**Subject: Request for Modification and Renewal of the Section 404 Individual Permit and Section 401 Individual Water Quality Certification, and Catawba Riparian Buffer Authorization** for the Widening of NC 150 from the NC 16 Bypass in Catawba County to just west of the US 21/NC 150 Interchange in Iredell County, including the Interchange with I-77. Federal Aid Project No. STP-150(19), Division 12, TIP No. R-2307 and I-5717.

**References:** 1) Section 404 Individual Permit, Action ID No. SAW-2018-02343, issued September 3, 2020;  
2) Section 401 Individual Water Quality Certification and Catawba Riparian Buffer Authorization, NCDWR Project No. 20181732, issued April 17, 2019

The purpose of this letter is to request renewal of the existing U. S. Army Corps of Engineers (USACE) Section 404 Individual Permit and N.C. Division of Water Resources (NCDWR) Section 401 Water Quality Certification (WQC) and Catawba Riparian Buffer Authorization.

PERMIT DRAWING
SHEET 18 OF 22

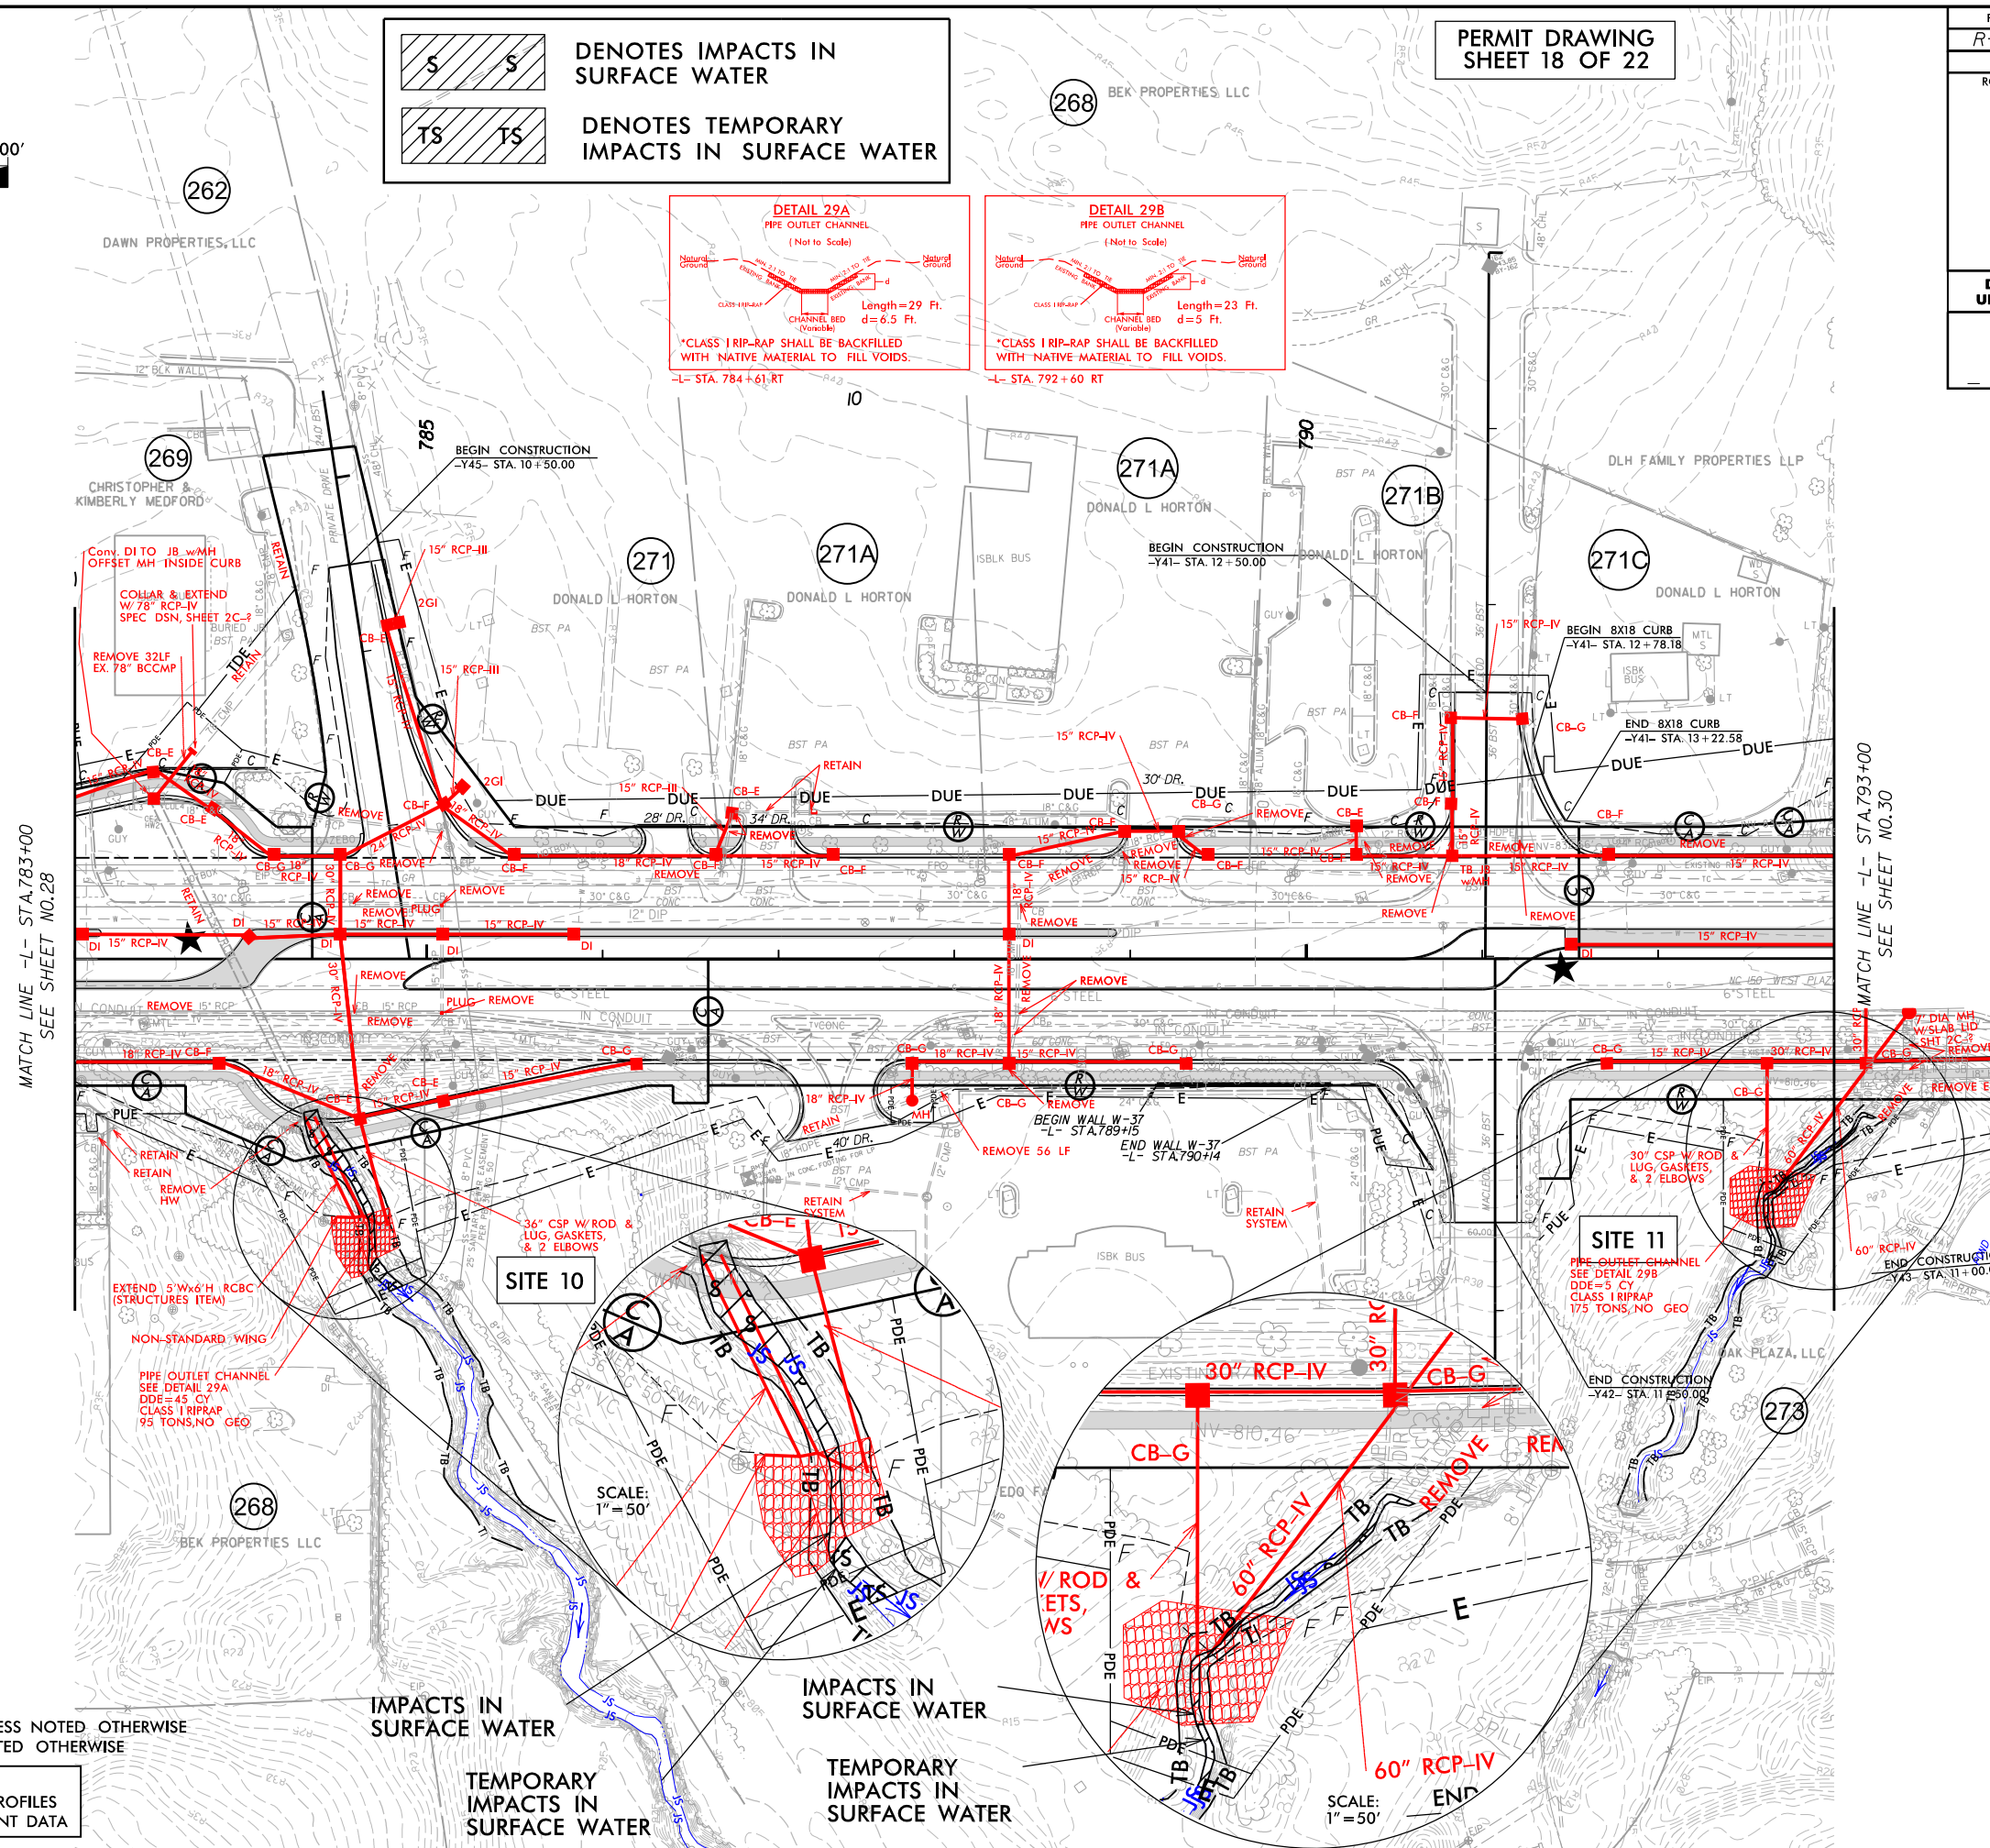
6. Site 10: The previous design proposed a 9' diameter precast manhole connecting an existing RCBC to a proposed 78" RCP at the downstream culvert extension at 784+50 RT (Permit Site 10). NCDOT determined that attaching a precast manhole to the existing RCBC is not feasible and would require a cast in place connection. To avoid this situation, the existing 5'W x 6'H RCBC will be extended. This will result in the outlet of the RCBC shifting 3' west of the previous 78" RCP outlet. However, the inverts, lengths, and channel layout will remain the same. There are no changes to stream impacts.

NC DEPARTMENT OF TRANSPORTATION
DIVISION OF HIGHWAYS
1/29/2024
CATAWBA/IREDELL COUNTIES
R-2307B / I-5717
37944.1.FR5 / 50134.1.FS1
SHEET 22 OF 22

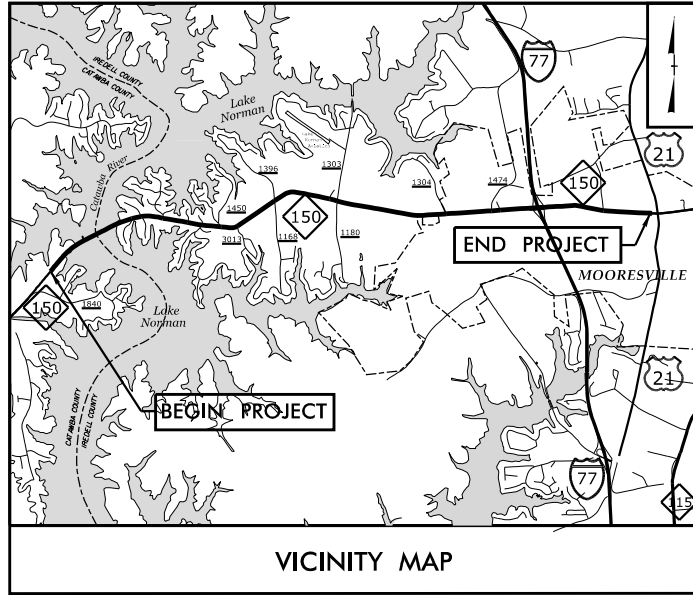
7. Site 12: Permanent impact decreased from 28 to 27 linear feet due to a corrected measurement (The change is only reflected on the Impact Summary Sheet, no change to the plan view).

8. Impact Summary Sheet: Impacts on the previous version were shown to nearest 0.01 acre and now show the nearest 0.001 acre.
